DECISION DELEGATED TO HEAD OF PLANNING

Application No: H02-0820-23 **Applicant:** Mrs L King

Proposal: Convert existing garage to a habitable sitting room and erect a new brick garage adjacent

Location: 37 Normanton Road Crowland Peterborough

PROPOSED GROUND FLOOR PLAN 1:50

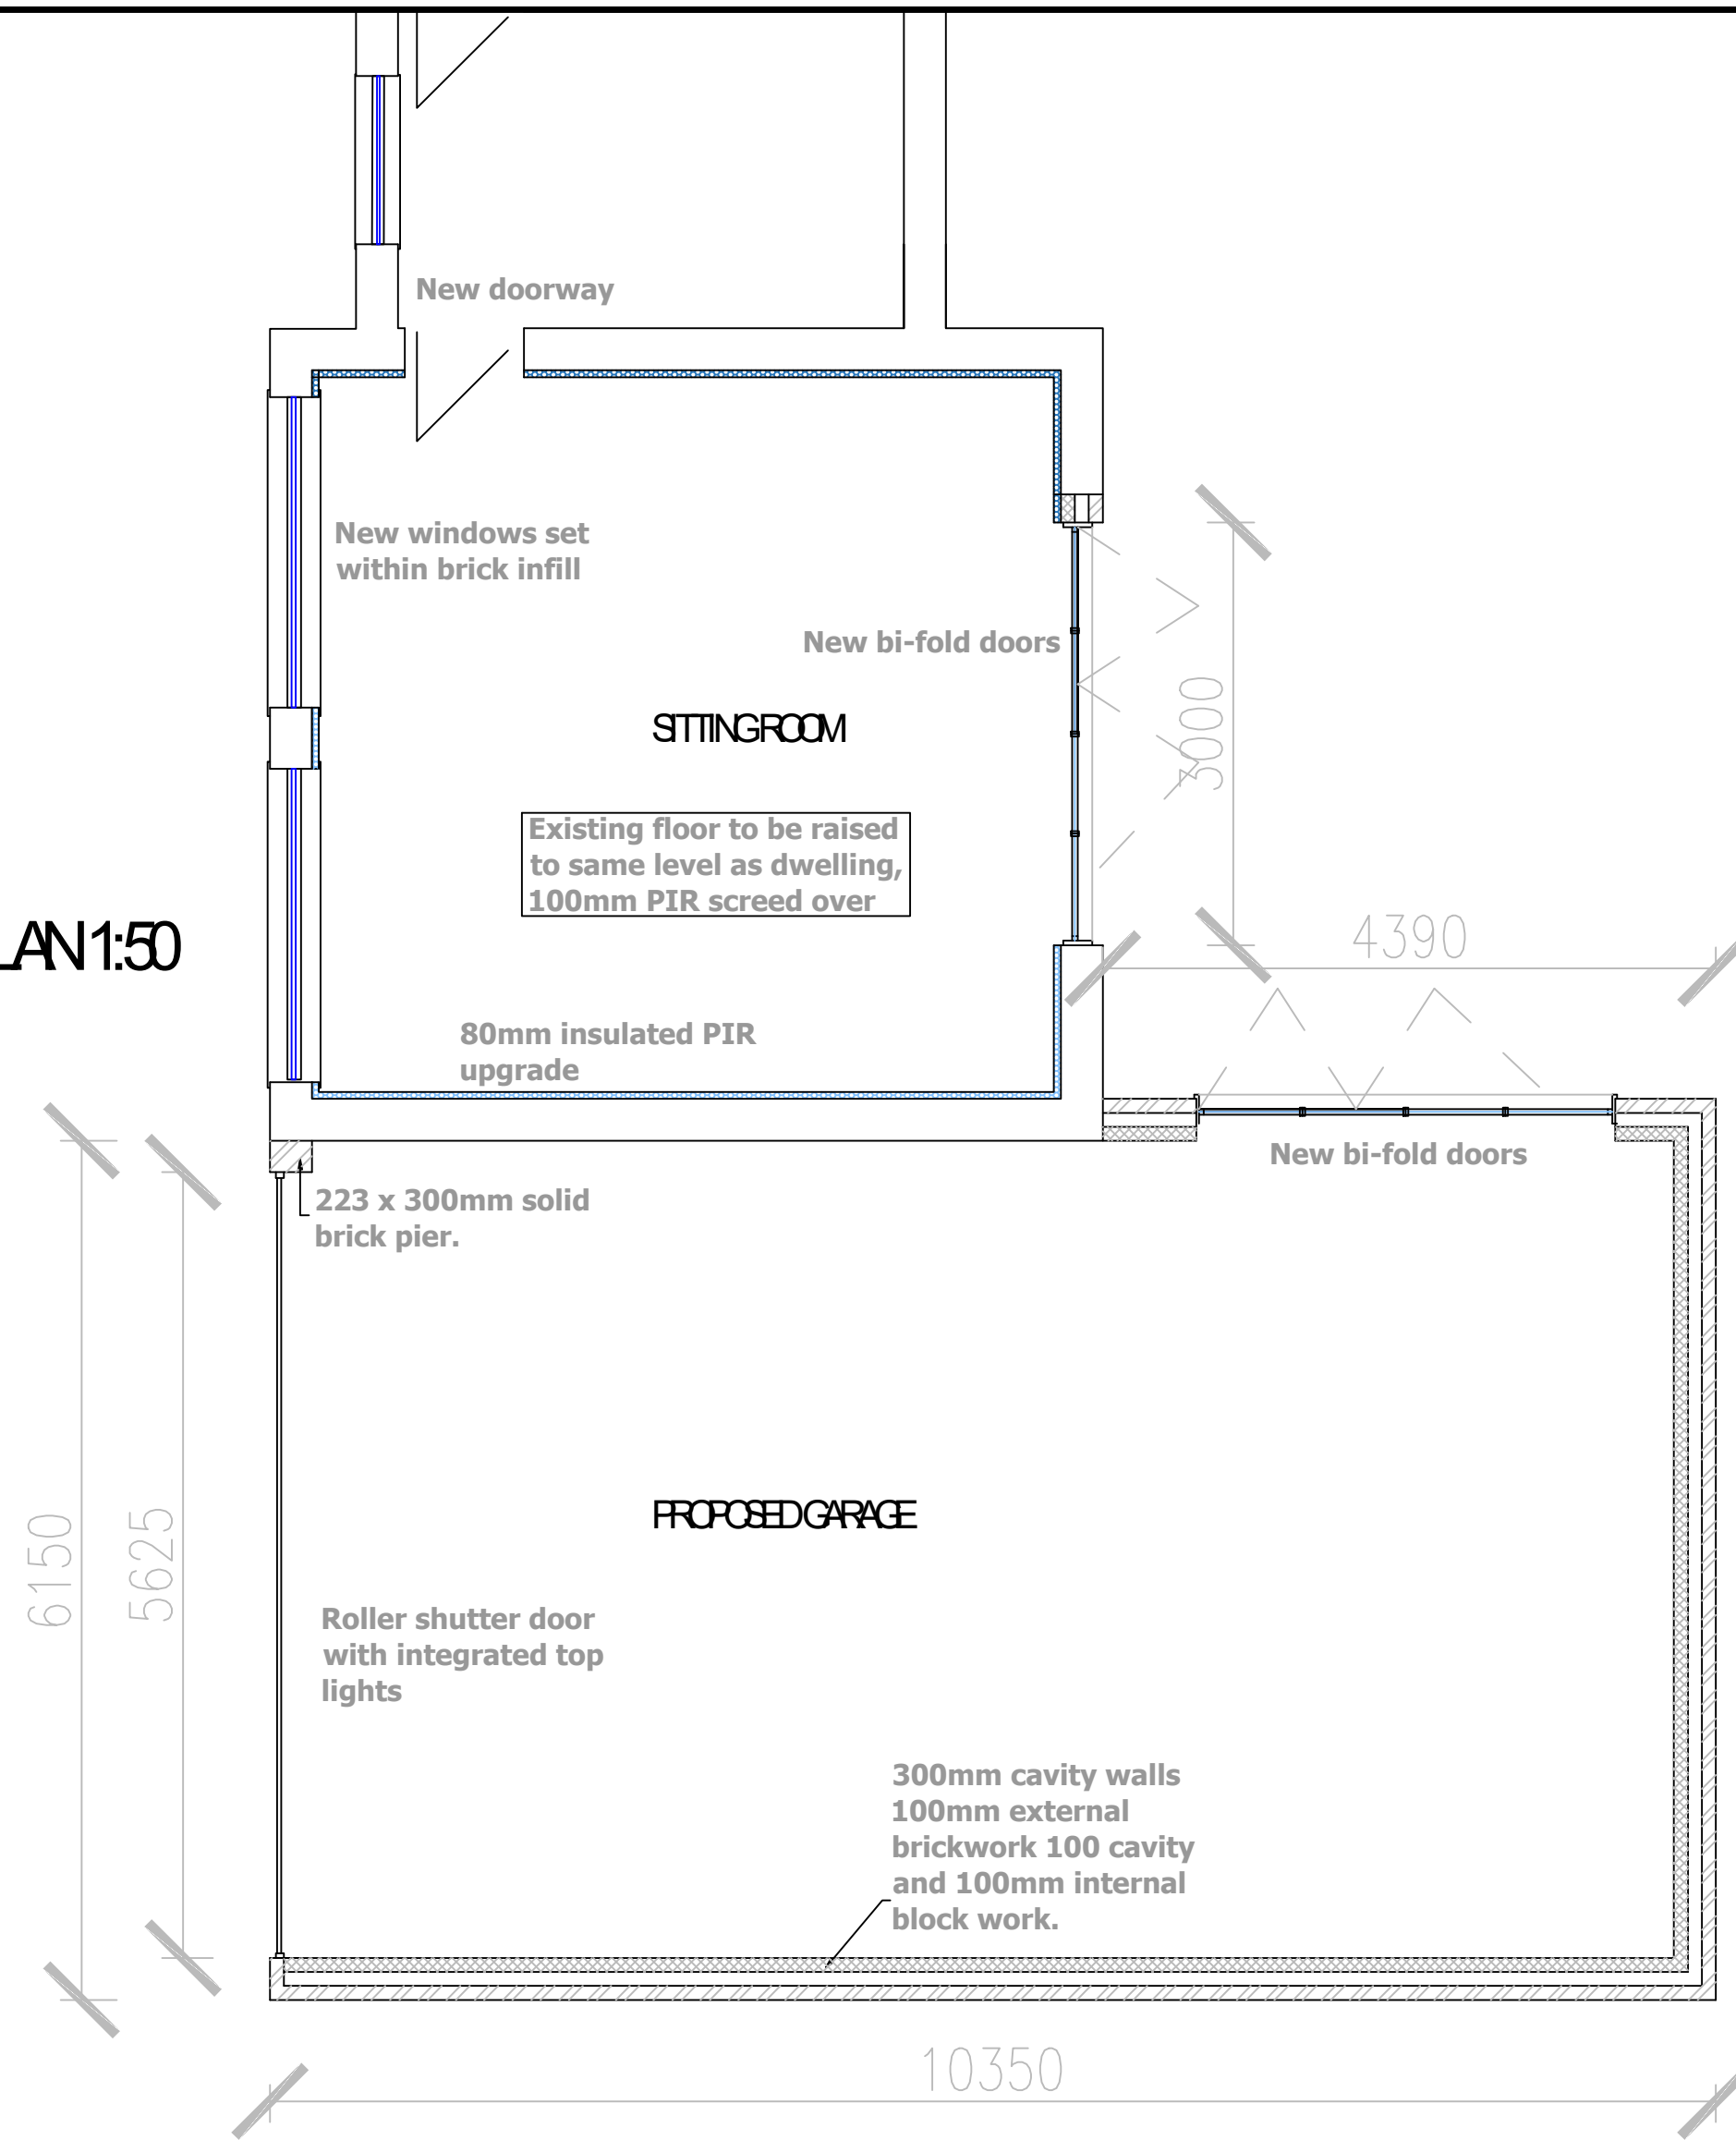
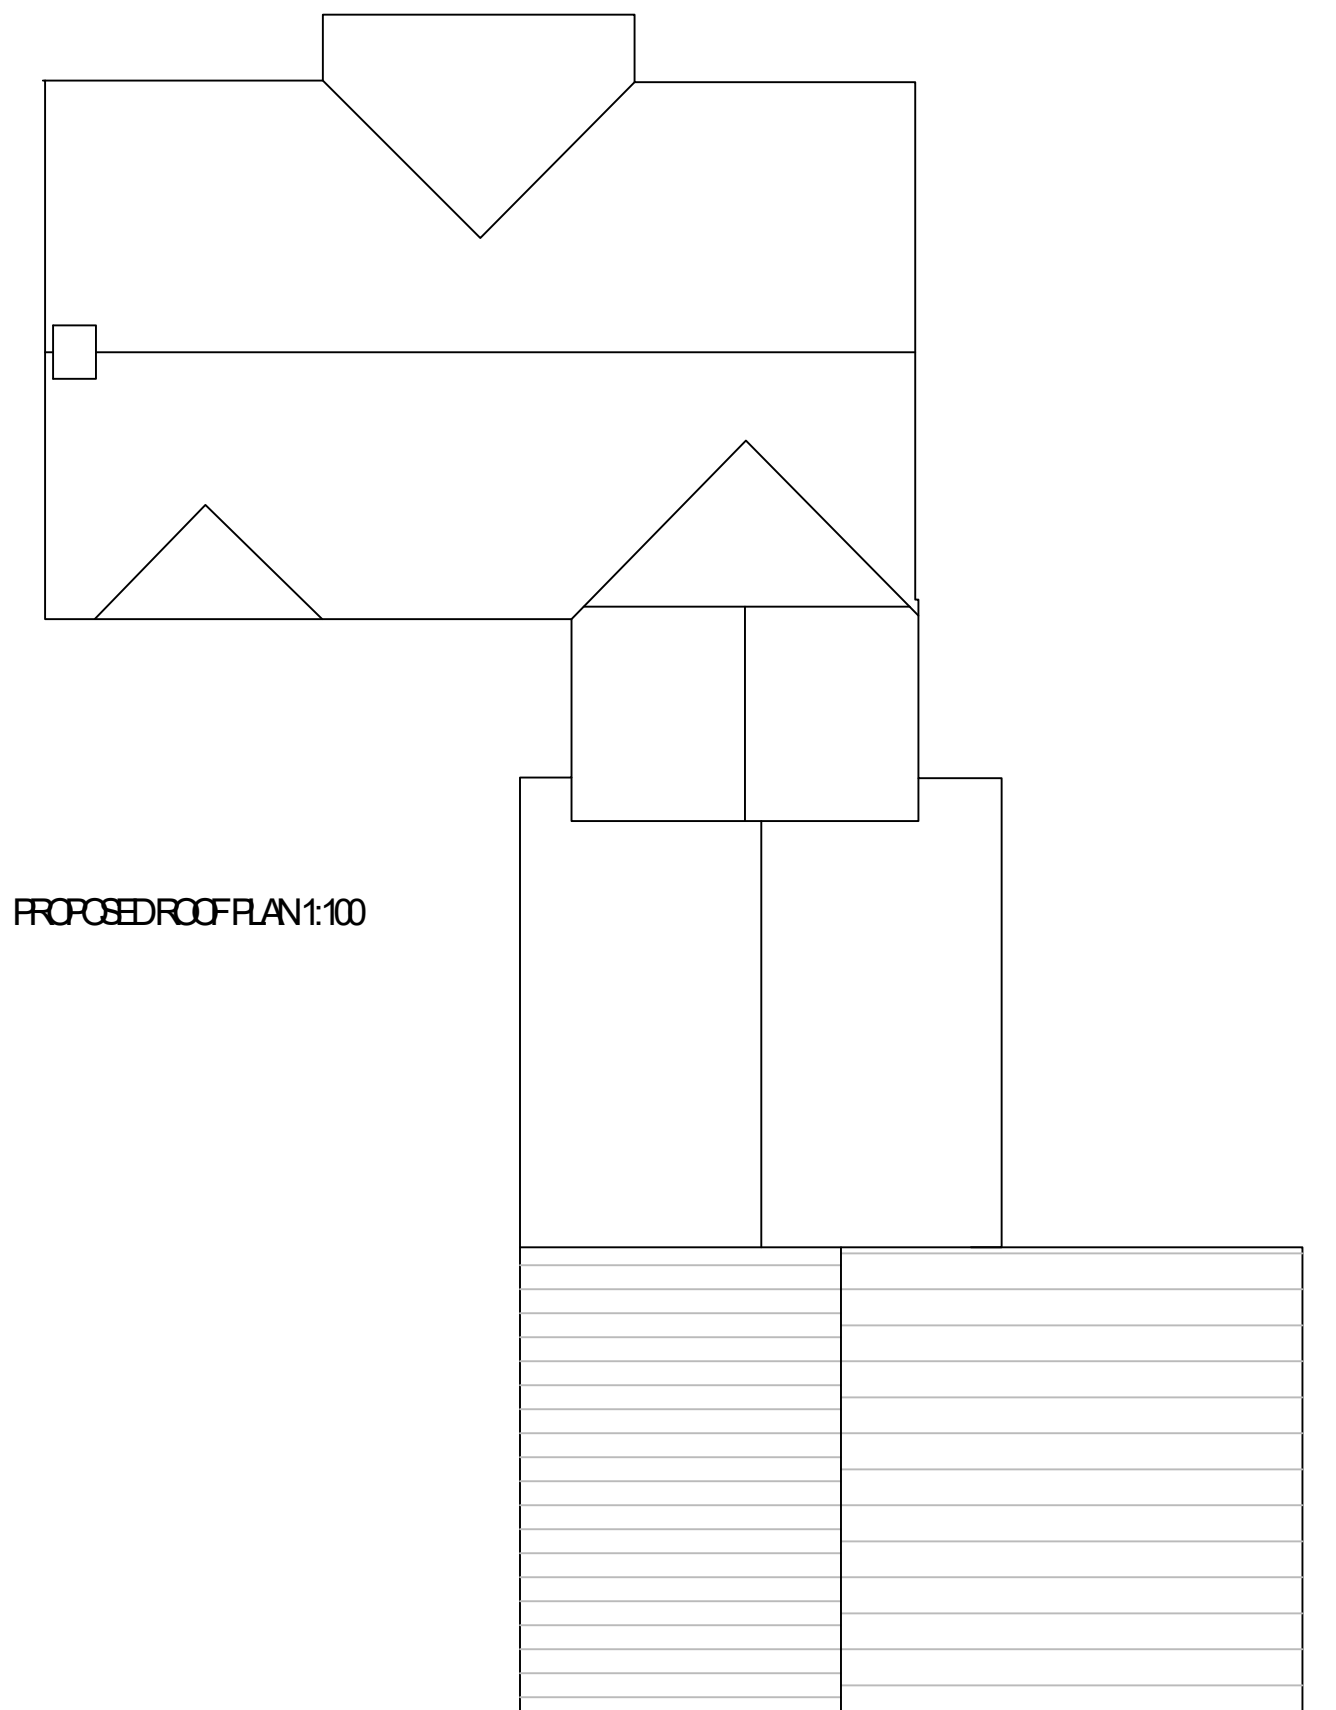
The proposed room will directly overlook the shared drive and create a feeling of overlooking onto the adjacent property by inserting new windows into habitable rooms. There is also the potential for direct overlooking into number 35's habitable windows.

There is a reasonable concern that the new room, albeit marked in the plans as a sitting room, will in fact be used as an additional bedroom. This will increase the number of residents inhabiting the property, therefore leading to increased pressures in parking. This additional need, of what will in effect be a 6 bedroom property, will place pressure on what is already a small drive and lead to a detrimental impact upon local parking and amenity.

- The proposed extension is not considered to cause a loss of privacy for No. 35 as the shared drive is not a private area in this regard (i.e. a rear garden) and similarly No. 35 themselves would be able to look out onto the shared drive and have an equally clear view on the area. Further to this, there are already windows on this elevation on the first floor which look out onto the driveway and therefore there will be no new issues. Finally, due to the positioning of the dwellings it is not considered that there will be direct overlooking into the habitable windows.

- The room is labelled on the plans to be used as a sitting room so the LPA has no reason to believe this won't be the case. However, if the room became an additional bedroom it is clear that there is enough vehicle parking to the front of the property for this additional room. The proposed garage would also act as an area for the residents to store their vehicles sufficiently and off the highway.

Scale: 1:100
Proposed Elevations 003 Paper size: A2

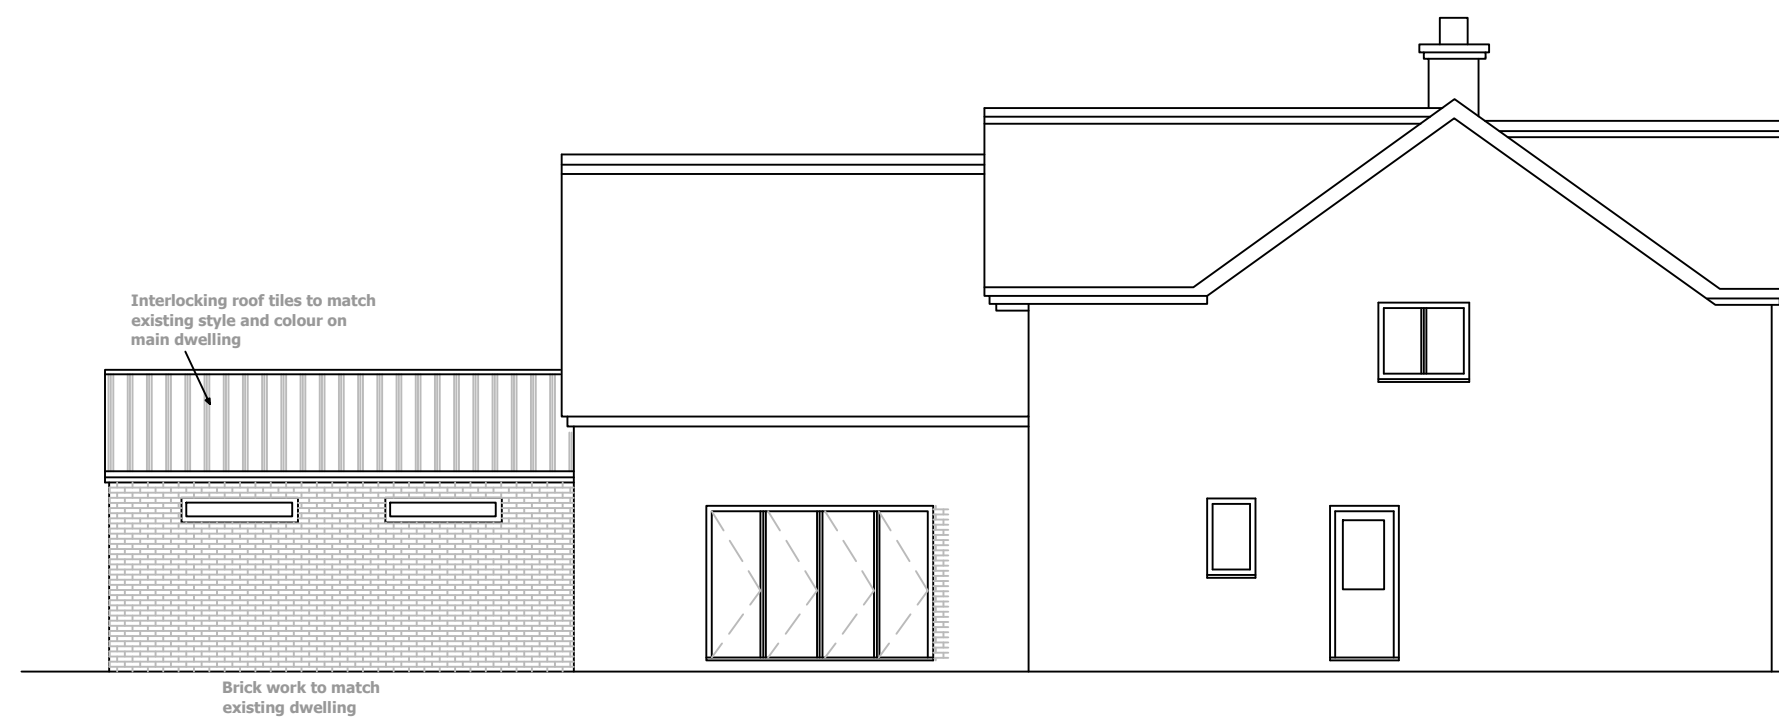
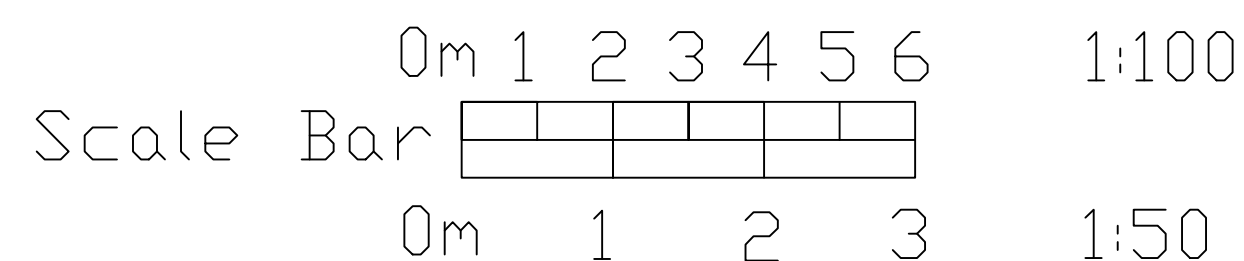
The garage will have a gable roof similar to the roof design on the dwelling and features a large roller shutter door with light panels just above this. There will be the addition of two new windows on the front elevation where the conversion is taking place to allow for natural light into what will be the new sitting room. At the rear of the garage there are two narrow windows which will be situated just above the average height, a similar thing will be on the side elevation. Finally, at the side of the garage and the rear of the sitting room there will be a set of bi-fold doors to allow for access into the garden. Overall, this design is considered to be acceptable as it will feature a similar roof design to the main dwelling and others in the area.

Finally, the materials that will be used on the development are as follows, the walls shall be made from a matching brickwork to the existing dwelling with the roof being made from interlocking roof tiles which shall also match the existing dwelling. By using similar materials it will ensure that the garage extension is in keeping with the dwelling and therefore not create any visual discrepancies. Prior to these materials being used, the proposed materials were insulated steel cladding for the walls and steel cladding sheets on the roof, to ensure this development could be approved an amendment was suggested by the LPA to change the materials so it matches that of the existing dwelling. It is therefore considered that this development is acceptable and in accordance with Policies 2 and 3 of the SELLP.

It uses materials such as a steel portal frame, which are not compatible with the surroundings. It therefore causes significant detrimental visual and character impact to the surrounding area and properties.

- Following on from the amended plans received, these materials have since changed and therefore are considered to be acceptable as they now match the existing dwelling and ensure the garage does not stand out.
